Application number: 2019/91327	
What is the application for?:	Reserved matters application pursuant to outline permission 2017/90207 for erect
Address of the site or building:	Thongsbridge Mills, Miry Lane, Thongsbridge, Holmfirth, HD9 7RW
Postcode:	HD9 7RW

Objection to planning application 2019/91327 on the following grounds;

1_Huddersfield Road Elevation 1: 200

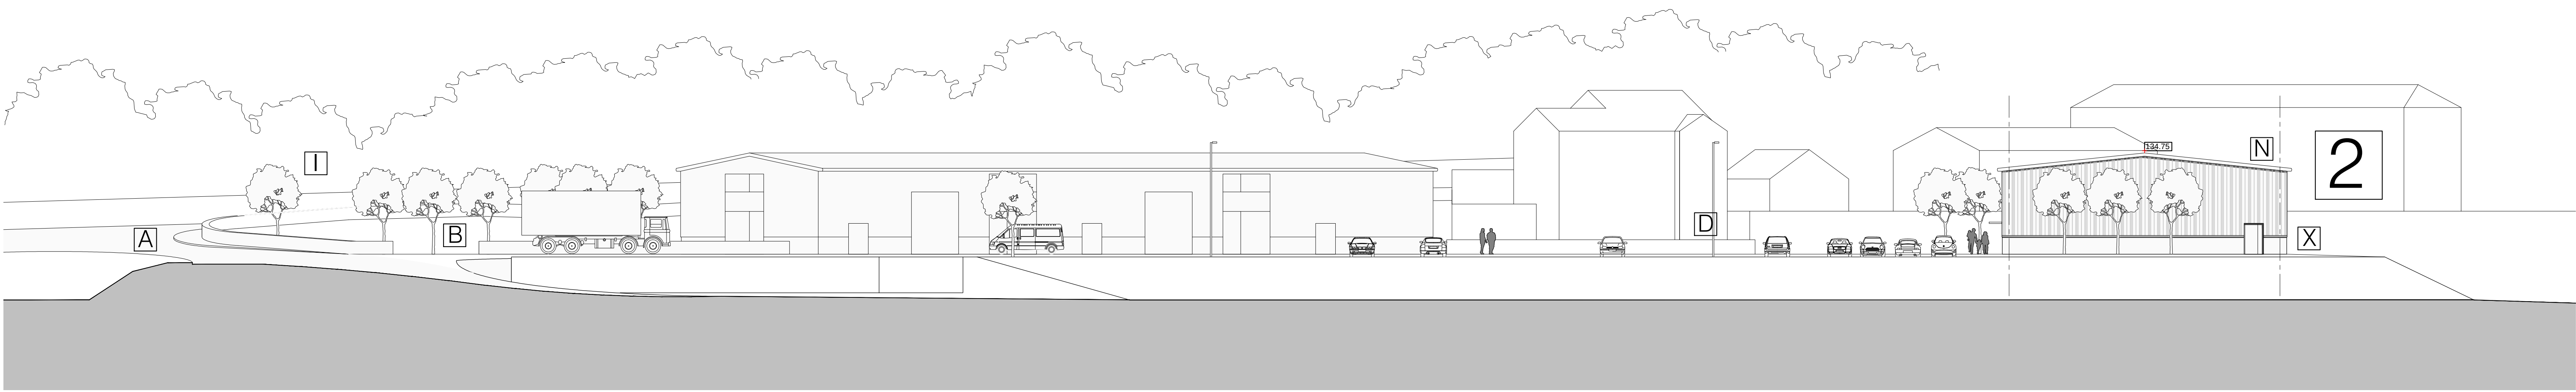
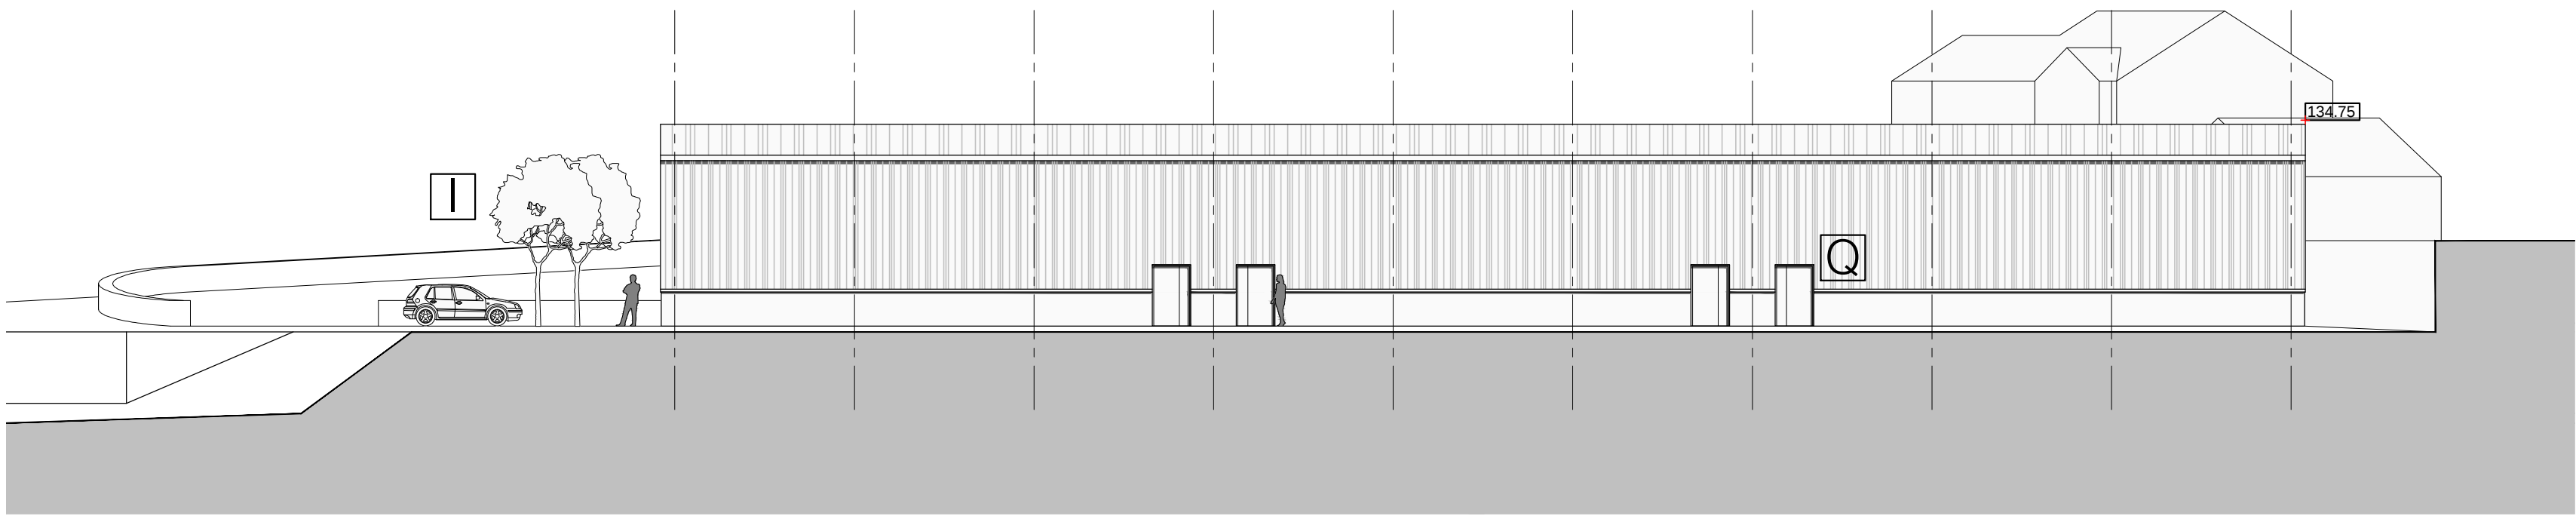
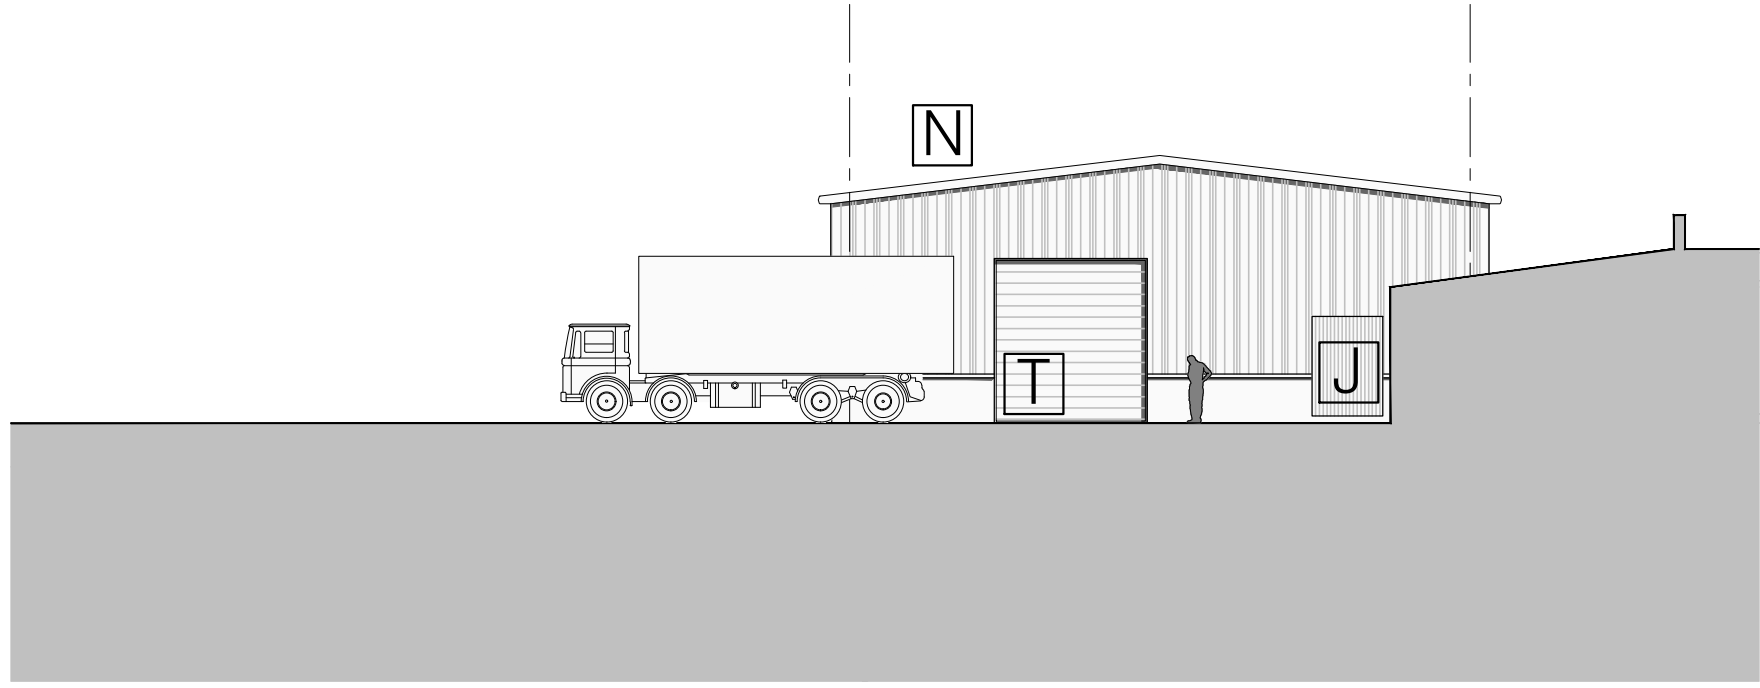
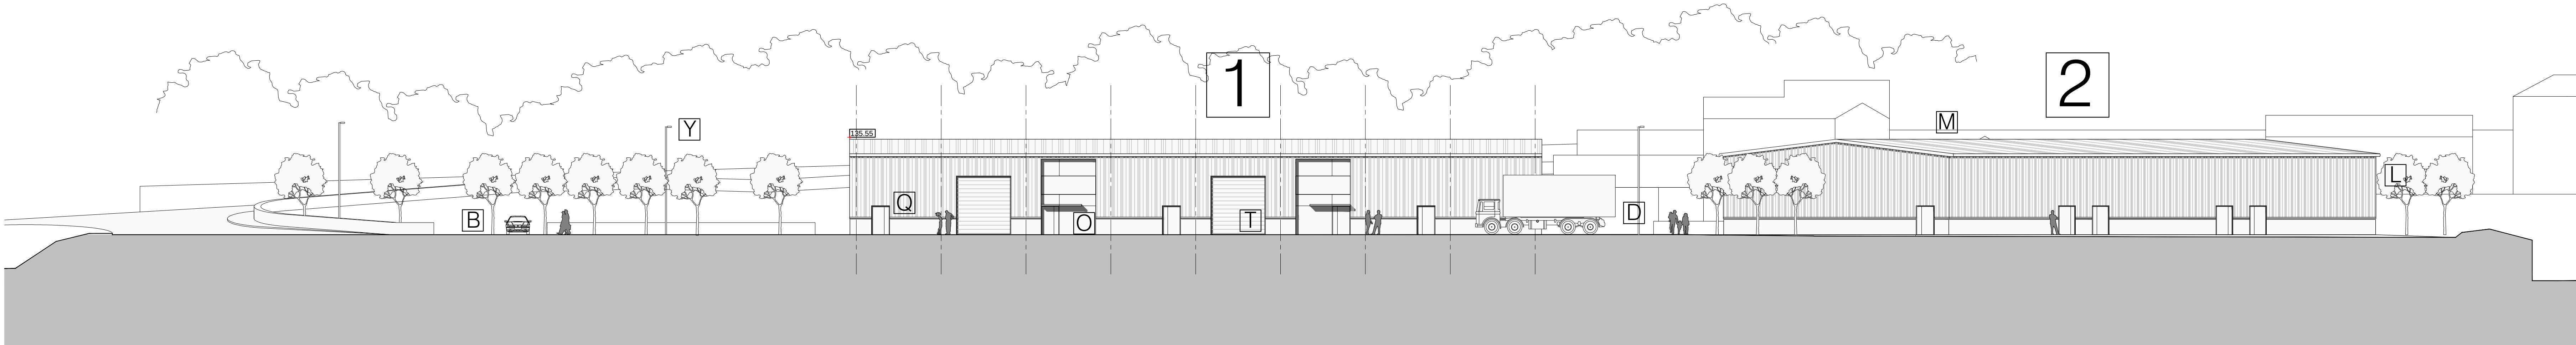
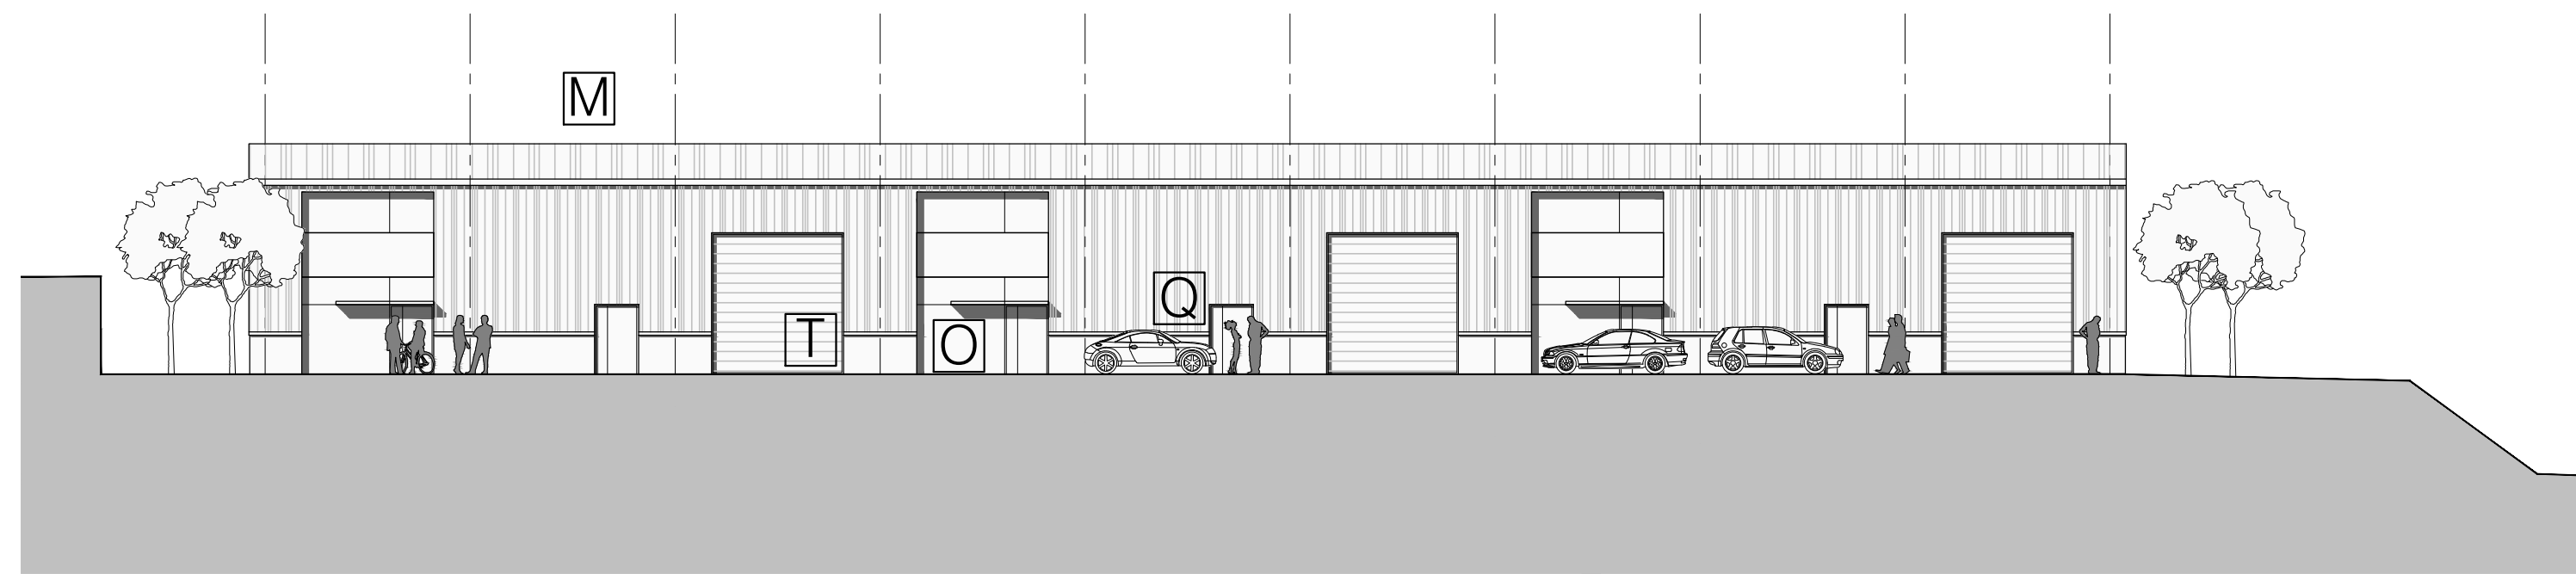
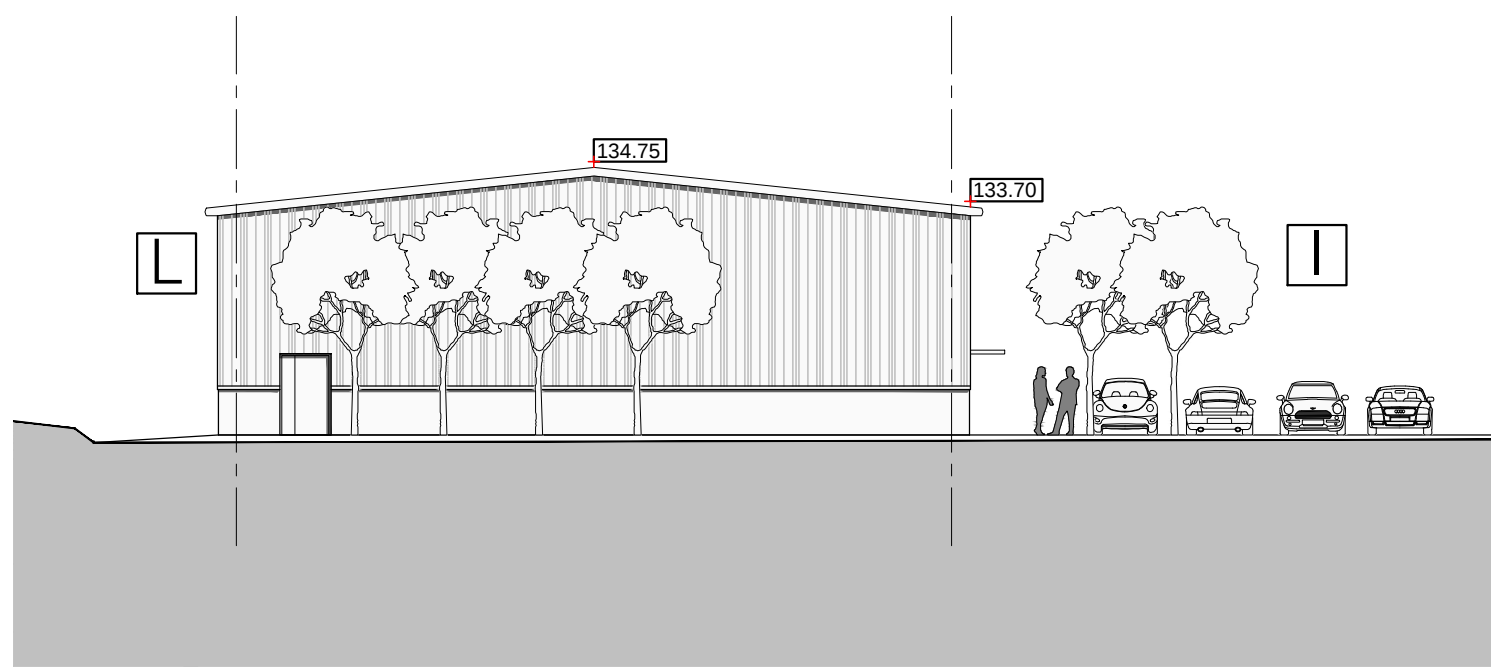
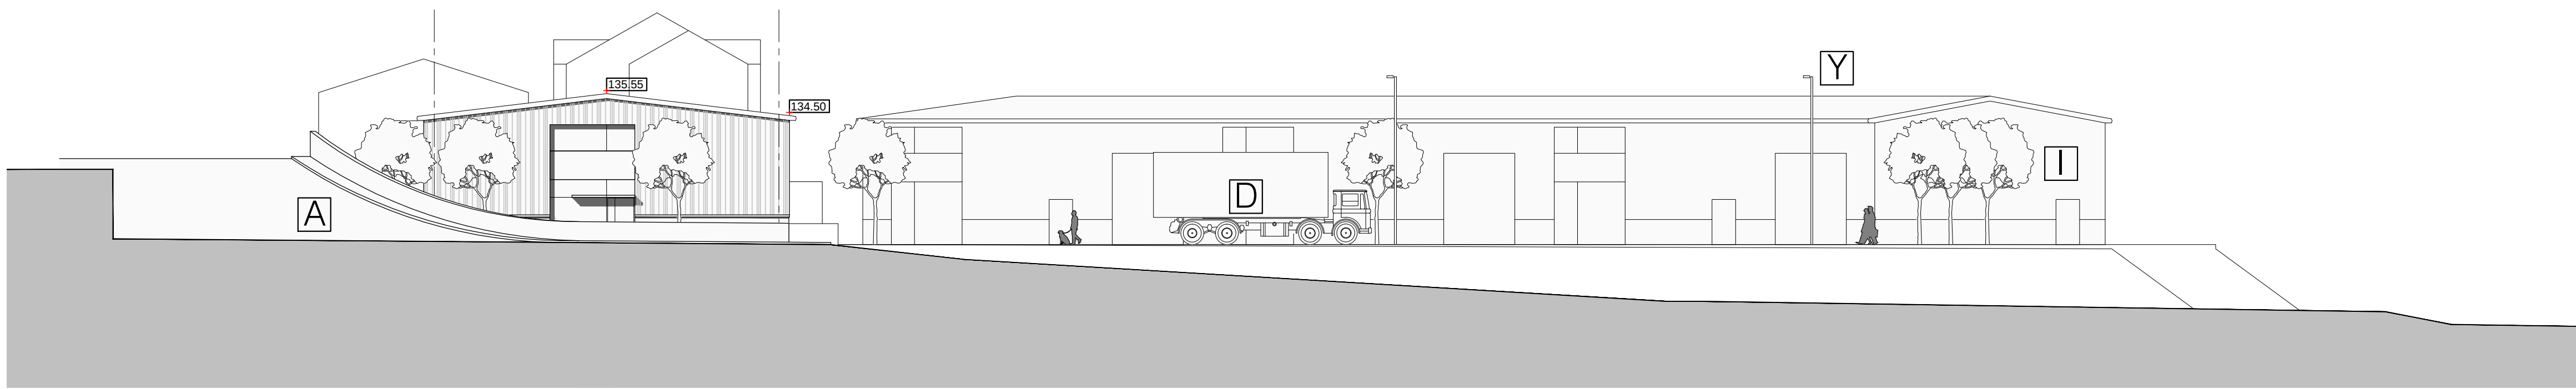
Type of comment: An objection	
Hello Mr Wakefield again we wish to strongly object to the layout of this proposed of this scheme the building is huge and the impact on our living with be immense we will literally look out onto a huge industrial corrugated unit all the points we strongly stand by why can this site not be designed to take our living into consideration. This site is huge and we are not against the sites development we are against the huge impact the shear size and what it will have on our well being and living We will be blighted every moment of our home life with this enormous building as pointed out in our object before the following is the main aspect of our living accommodation. The proposal will have an overshadowing impact on our living accommodation and areas from early morning to afternoon. Our natural light will therefore be seriously compromised for at least 6 months of the year. To summarise, the proposal, will have a considerable overbearing negative impact This will seriously blight our property and have a huge negative impact on our day to day living and well-being. I am begging the council would you want to look onto this enormous building can it not be more sympathetically designed could the parking or turning circle be here instead and enjoy our home this will have a dramatic effect on our living the thought of daily looking at a hugh unit is terrible and surely can not be allowed The proposed development in its current form will have a serious adverse impact on our residential amenity and will have an overbearing impact

and the scale and height of the proposed building. I seriously want this looking into the site shows no buffering and only 5 trees we do not feel that the council realise the height of this unit and its size

I do hope the council will put some serious consideration into this and its design surely low light industrial unit means low this unit is a monster of a unit

We would contend that the proposed development does none of the above. It does not, by way of form, scale, layout, appropriate distances between buildings,
in any way. And most certainly does not respect the character of the townscape.

The proposed development in its current form will have a serious adverse impact and will have an overbearing impact

and the scale and height of the proposed building.

The proposal will have an overshadowing impact on our living accommodation and areas from early morning to afternoon. Our natural light will therefore be seriously compromised for at least 6 months of the year.
